3RD PARTY INSPECTION FORM

RECORD OF THE INSPECTION OF A COMPONENT OR ELEMENT BY A NC LICENSED ARCHITECT OR ENGINEER

Residential Single Family Project: **Y** N Commercial Project: Y **N**
Code Enforcement Project No.: Permit No.: SFD2104-0032
Project Name: 2184 Wire Road Owner: Hopkins Drucilla Todd
Project Address: 2184 Wire Road, Bunnlevel Suite No.:
Date Inspected: 06/08/2023 Contractor Name: Schumacher Homes of NC INC
Component Inspected: Foundation

Project Name: 2184 Wire Road Date: 6 / 8 / 2023 GTA Rep: Payton Guerrero
 Project No.: 201253x093 Client: McGee Brothers Weather: Sunny Temperature: 75 °F

RIDGEWOOD CAROLINA / CUSTOM  
 BOLT AND PLATE PLAN

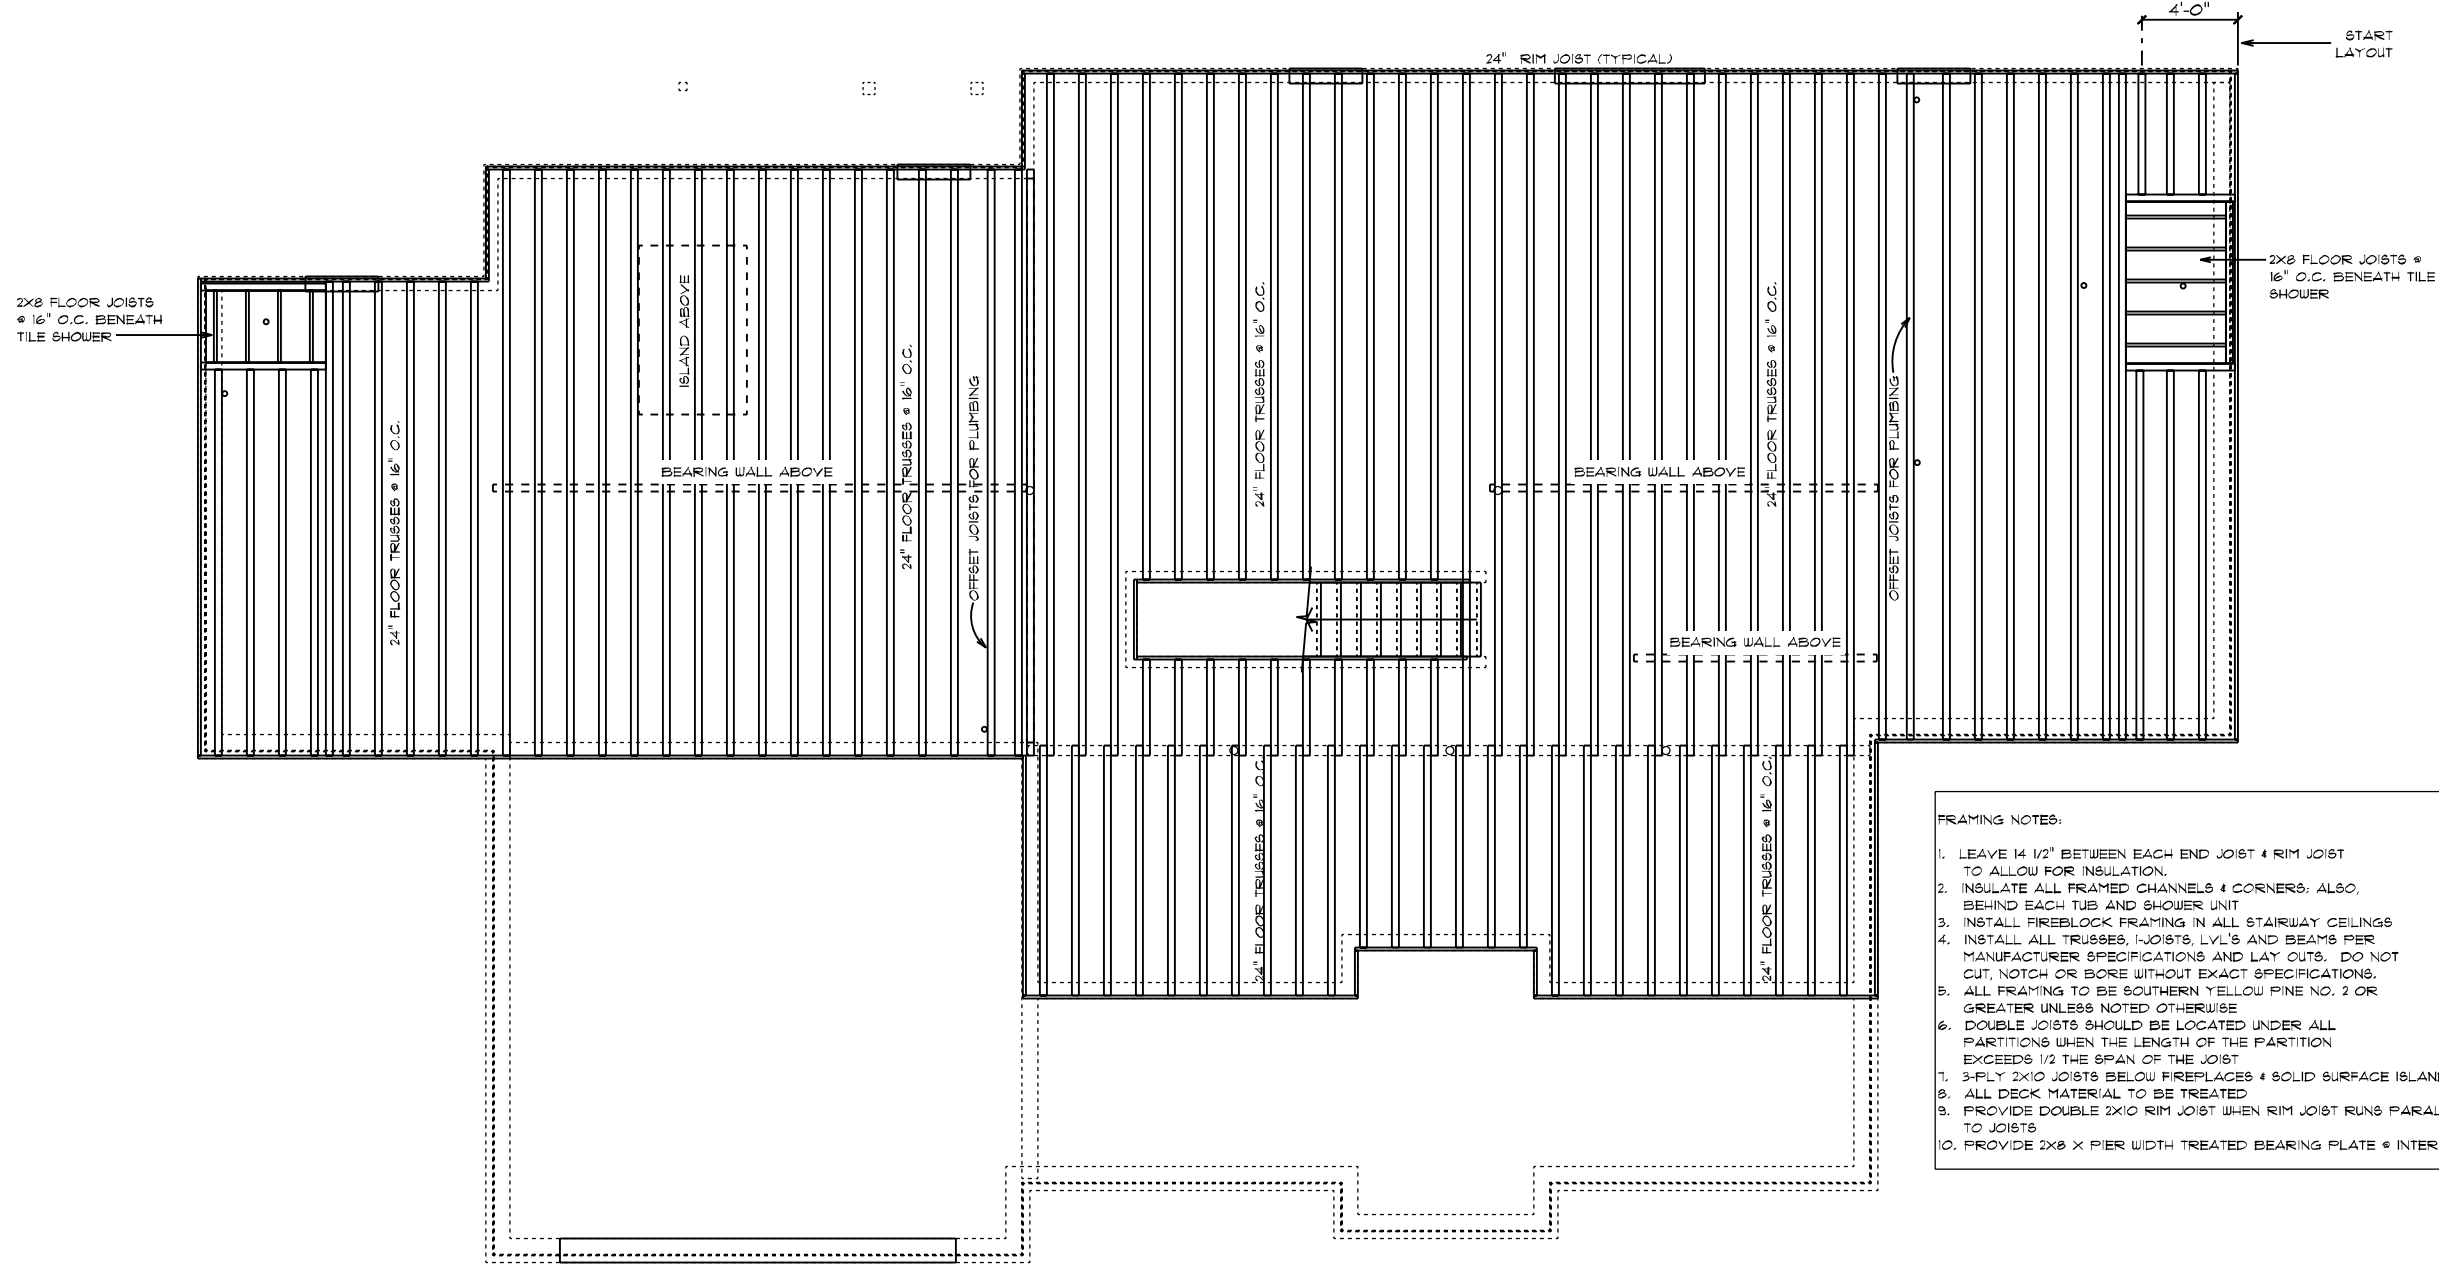
perimeter wall foundations, masonry (head/bed joints, anchor bolts), footing projection, (see attached report). Anchor bolt spacing exceeded 48-inches at isolated areas. Add anchor bolts as needed.

Additionally, on this date, GTA observed masonry foundation walls with regards to pier head size, head and bed joints, and anchor bolt placement. Based on GTA visual observations, the masonry foundation walls have been constructed in general accordance with the approved project drawings, with the exception of anchor bolt spacing at various locations (add anchor bolts as needed).

-anchor bolt spacing exceeded 48-inches at isolated areas. Add anchor bolts as needed.
